Formal Objection – Plot 1 West Elevation Intensification and Procedural Breach

Subject: Objection to Planning Application 2025/91887 – Plot 1, Lingards Fold, Slaithwaite

title:
Proposed North + South Elevations
drawing status: Planning drawn by: JD checked by: JD
drawing no.: 2510-PL-01-200 rev: -

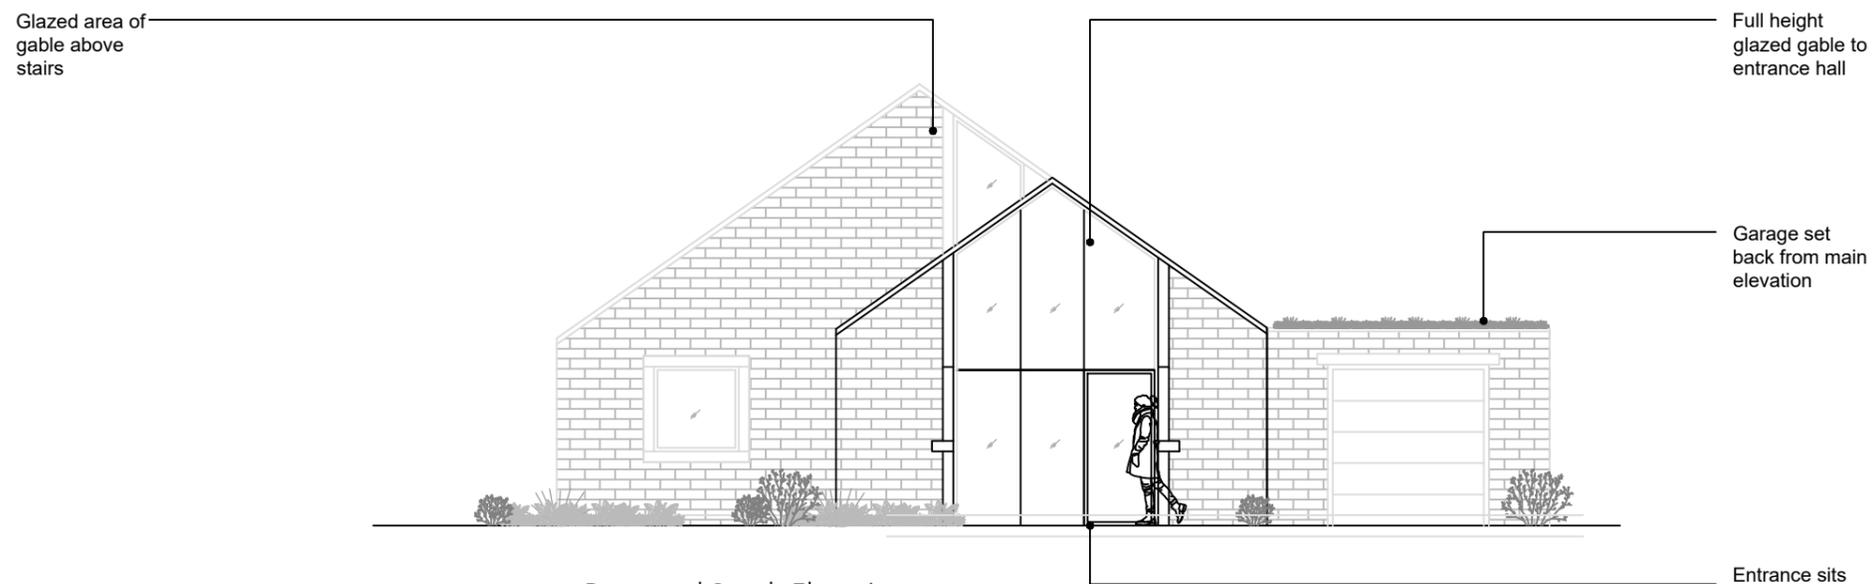
I am writing to formally object to planning application **2025/91887**, concerning **Plot 1 at Lingards Fold, Slaithwaite**. This objection focuses on the **west elevation**, which directly faces both the **Green Belt** and **public right of way COL/133/10**, and has undergone substantial intensification compared to the approved design under **2020/93954**.

Scaled analysis confirms a significant increase in visible built form on the west elevation:

Element	2020/93954 Area	2025/91887 Area	Absolute Increase	% Increase
Stonework	10.63 m ²	16.80 m ²	+6.17 m ²	↑ +58.0%
Roofing	7.30 m ²	12.18 m ²	+4.88 m ²	↑ +66.8%
Glazing	6.66 m ²	13.80 m ²	+7.14 m ²	↑ +107.0%

These increases materially affect the building's visual bulk, skyline impact, and reflectivity—particularly when viewed from the Green Belt and PROW corridor.

The **north-facing balcony** on Plot 1 is a full projecting structure—not a Juliet—and is **clearly visible from the adjacent Green Belt**. Its west-facing aspect sits just **6.48 m** from the PROW, while the **first-floor patio** is only **2.141 m** away.

These elevated features introduce direct overlooking, visual intrusion, and amenity loss for PROW users. Their proximity increases perceived massing and disrupts landscape continuity. Under Kirklees Policies **LP24** and **LP32**, this proximity is unacceptable and risks precedent-setting encroachment.

1. **Refuse application 2025/91887** on grounds of massing escalation, policy breach, and landscape impact
2. Require a **revised west elevation** that restores massing balance, reduces glazing, and mitigates reflectivity
3. Conduct a **site-wide design audit** to assess cumulative impact on the Green Belt and PROW corridor
4. Initiate **enforcement proceedings** regarding the unauthorised retaining wall and its proximity to public land
5. Ensure **disclosure of the wall's status** to all incoming homeowners prior to any Management Company share transfer
6. Reassess the **balcony and patio proximity** to the PROW and Green Belt, and require removal, screening, or redesign to preserve amenity and openness
